Our Ref: 208212_LEO_006.docx

MINOR MODIFICATION OF ORANGE WASTE PROJECT APPROVAL MP09_0025 – RESPONSE TO PUBLIC SUBMISSIONS

Response to Public Submissions – Orange Waste Project Minor Modification MP09_0025

PROJECT NUMBER: 208212	DRAWING NUMBER: 24_ EV13	REV: E
SOURCE: SIX VEI/ER

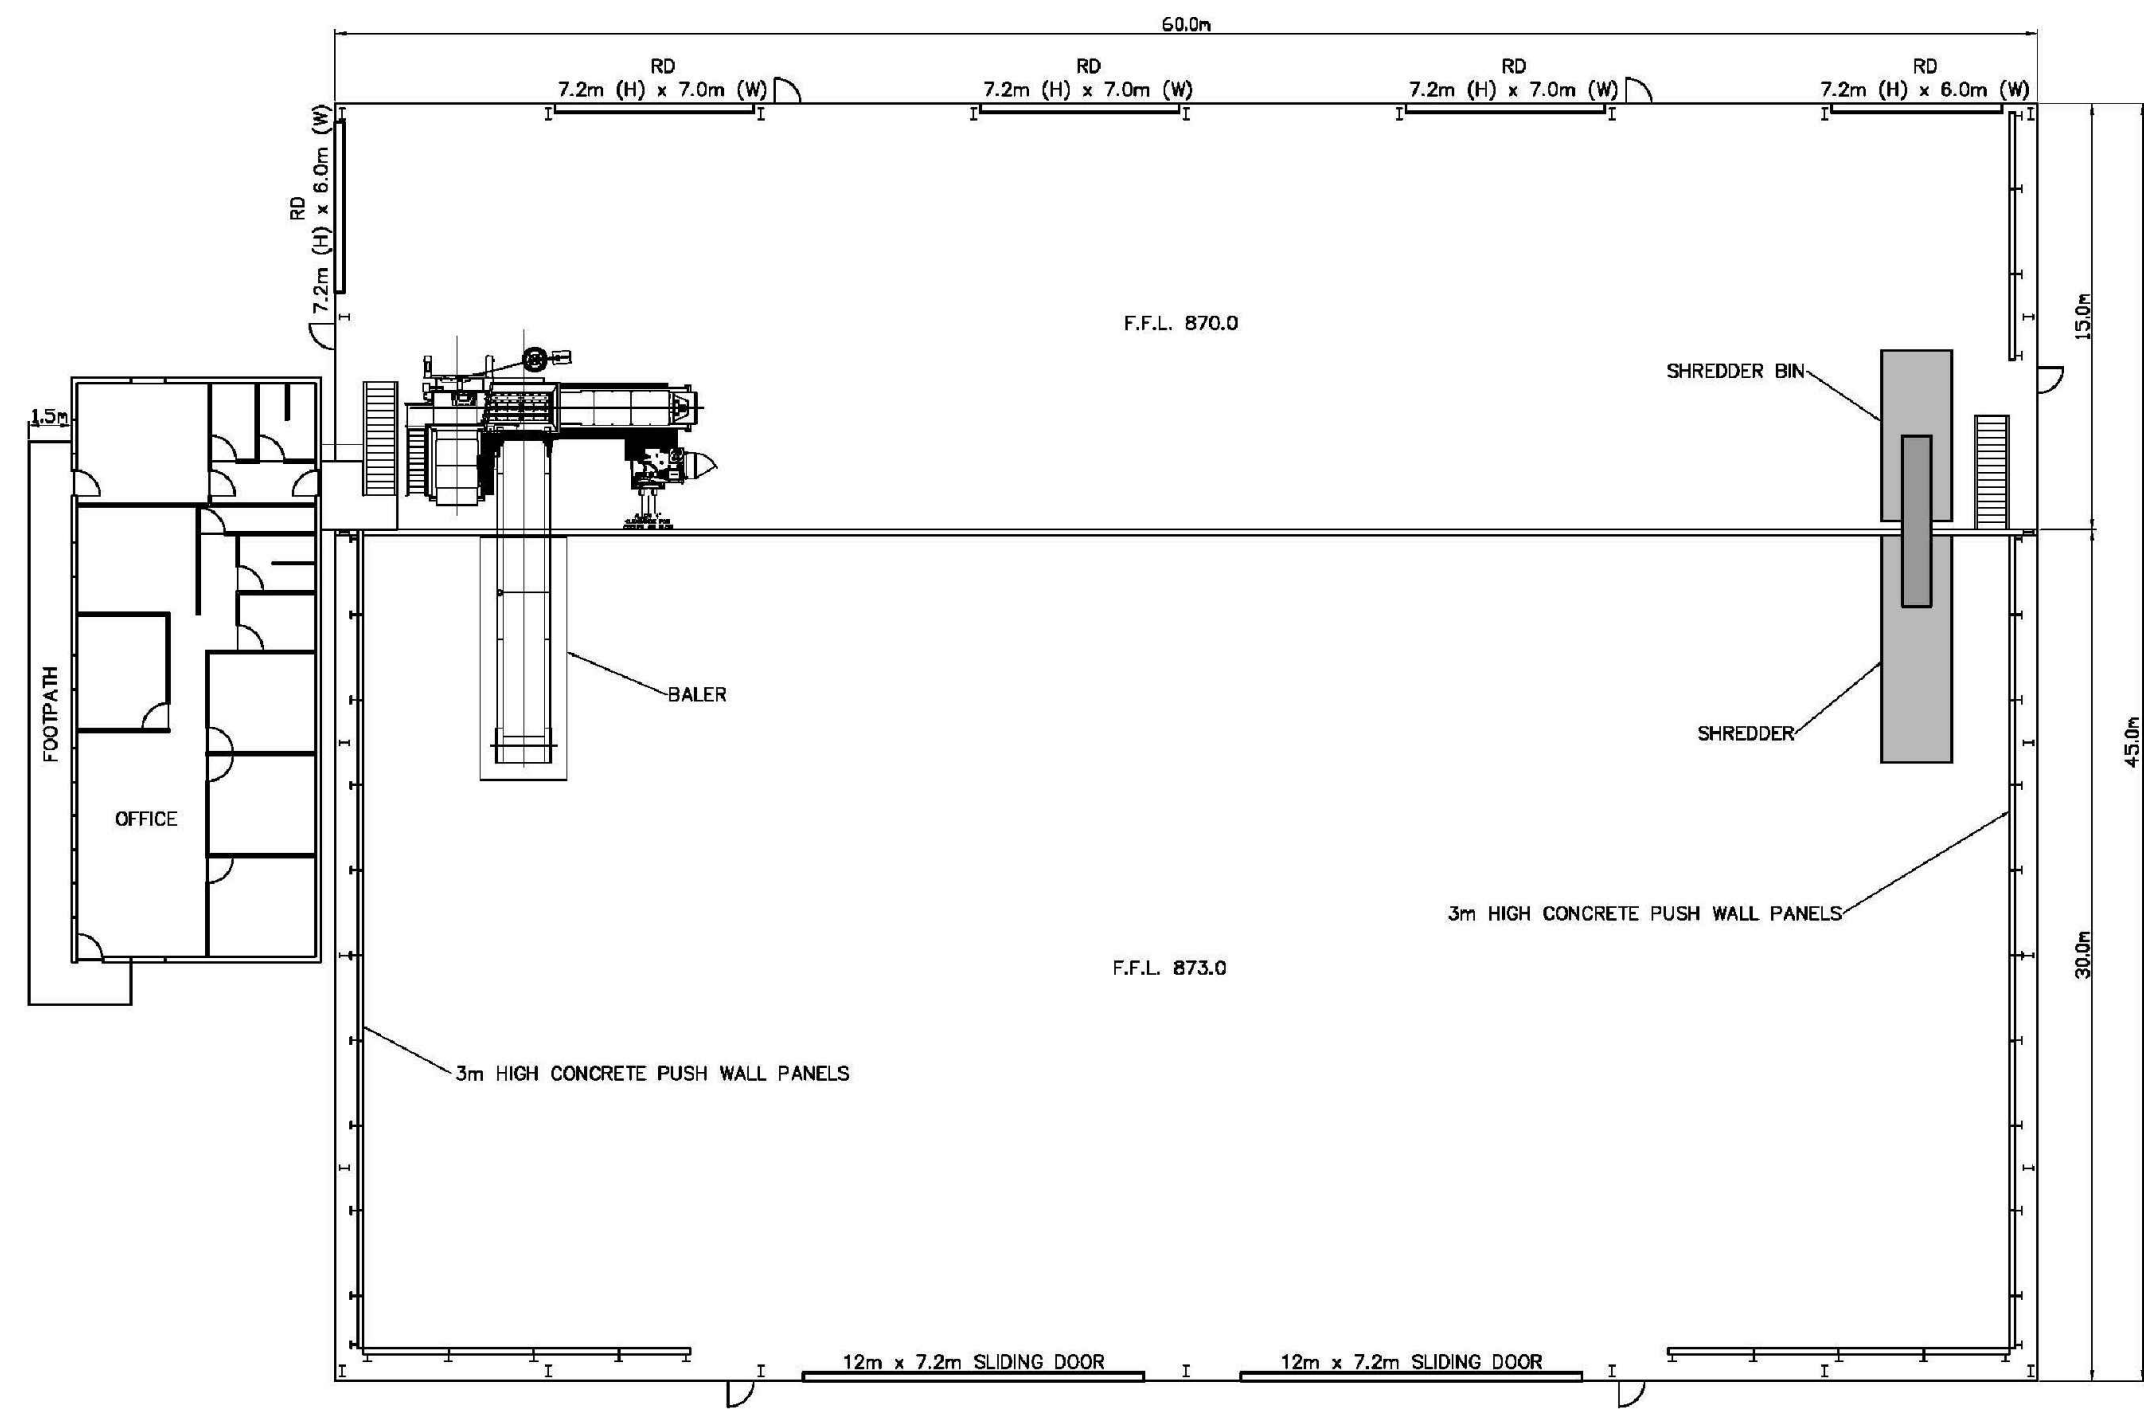
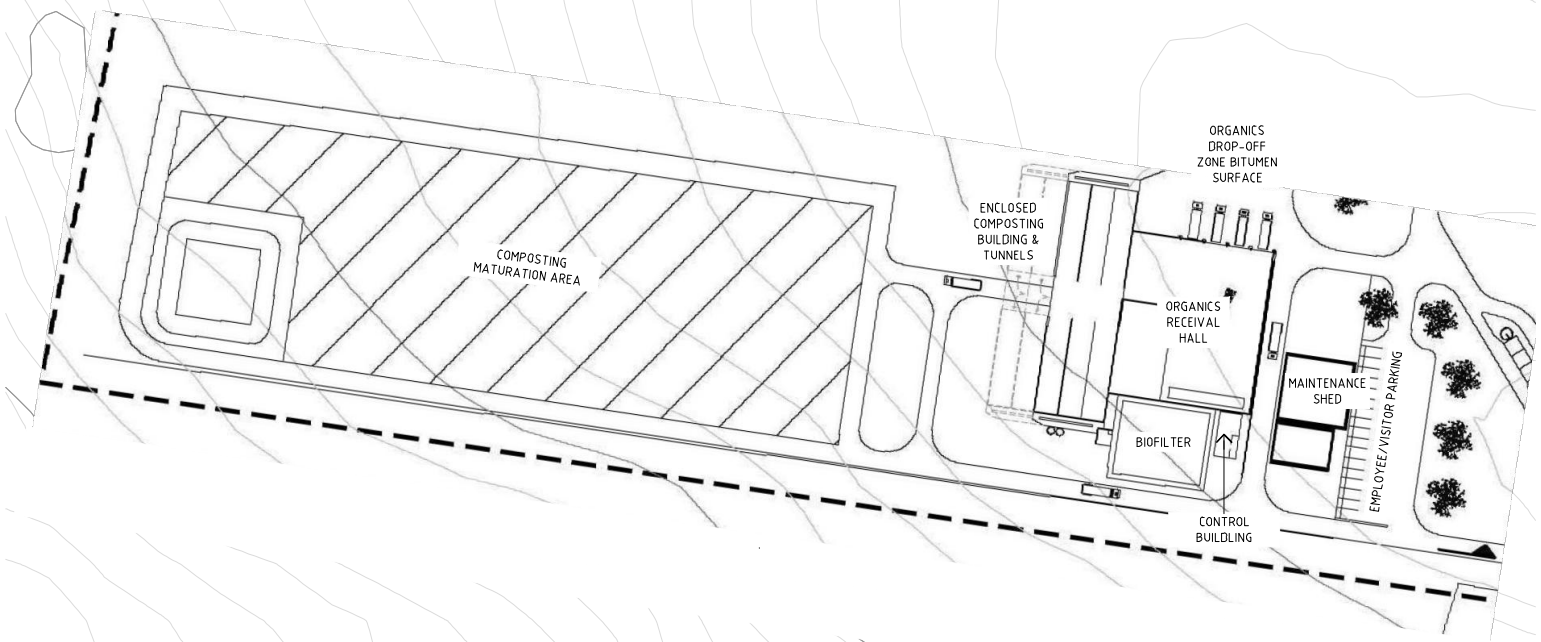
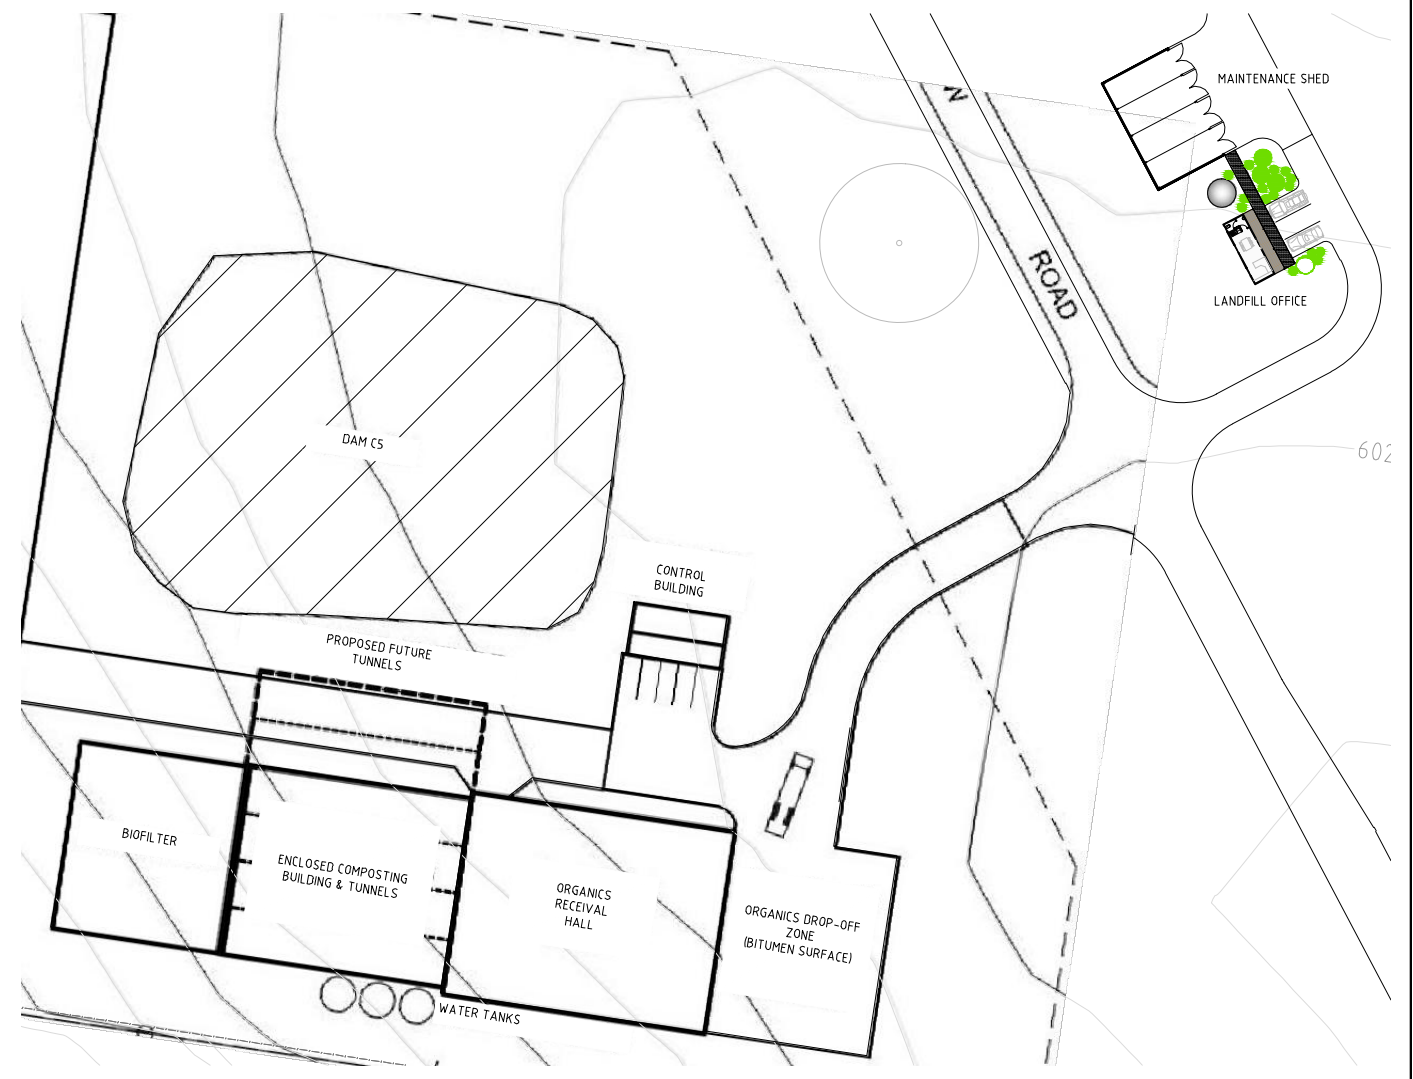
Issue No.	Comment	Response
1	Presence of the shredder at Euchareena Road	It is acknowledged that the shredding facility is shown in the proposed modification plan for the Euchareena Road site in error. This is due to the focus of the modification application being on the location of Council facilities at the Euchareena Road site; no changes were proposed to the compost operations consistent with the Project Approval. As such, the approved plan was only modified to the extent that was necessary to show the change to Council facilities at the site. To clarify the situation, revised Drawings EV13 and EV14 have been prepared which clearly demonstrates that there are no shredding facilities at the Euchareena Road site. As such, there will no longer be a major noise source at this location. Further to the above, the project will be required to ensure noise levels are below 40dB(A) during construction and 35 dB(A) during operations for residences on privately owned land, in accordance with Condition 26 of Schedule 5 of Project Approval MP09_0025. This is consistent with, and has been developed to address, the Project Approval.

2	Loss of landscaping around the buildings at Euchareena Road	Screening and bunding is to be maintained as per the original Project Approval. They can in fact be seen on original Drawing EV13 however due to the colour used it is acknowledged that this is not clear. As no change was proposed to either the screening or bunding they were not discussed in the modification report. To clarify this matter, revised Drawing EV13 demonstrates that the screening and bunding are to be maintained as approved.

3	Screen bunds and surface water dams do not appear on modification plans	Screening and bunding is to be maintained as per the original Project Approval. They can in fact be seen on original Drawing EV13 however due to the colour used it is not clear. As no change was proposed to either the screening or bunding they were not discussed in the modification report. To clarify this matter, revised Drawing EV13 demonstrates that the screening and bunding are to be maintained as approved. The proposed dams were not shown on the approved layout plans for the Euchareena Road site, refer page 30 of the Project Approval MP 09_0025. As such, they were not shown on the plans proposing to modify this layout. Three dams are shown on the plan on Page 28 of the Project Approval, reproduced on Drawing EV13 and marked '<i>previously approved site plan</i>'. Dams A and B remain as per Project Approval MP09_0025, see revised Drawing EV13. Following the award of tender and the completion of detailed design, dam C has now been split to form 5 smaller dams (dams C1 – C5) located around the composting facility, with a view to meeting the requirements of Project Approval MP09_0025. These are shown for clarity on revised Drawing EV14 by comparison to the approved layout plan. The dam function has not changed and the revised plan is considered to be consistent with the initial consent requirements.

3	New plan at Euchareena is impossible to read, are the dams still at the site? Road/building changes not shown	It is accepted that the proposed modification plans are difficult to interpret with respect to the dams and road layouts. This is because the focus of the modification application was on the location of Council facilities at the Euchareena Road site, and no changes were proposed to the composting operations consistent with the Project Approval. Since the modification was submitted to the Department of Planning, a tender has been awarded by the proponent for the operation of the facilities at both the Euchareena Road and Ophir Road sites. Revised Drawings EV13 and EV14, together with new Drawing EV15, provide clarity about the arrangement of the Euchareena Road site, and the location of the landscaping, bunding and on-site dams. This is done to address the Project Approval requirement (Schedule 5, Conditions 35-36) of the Department of Planning's approval (Condition 8). Contour detail has been removed from revised Drawing EV13 to make it easier to understand the plan.
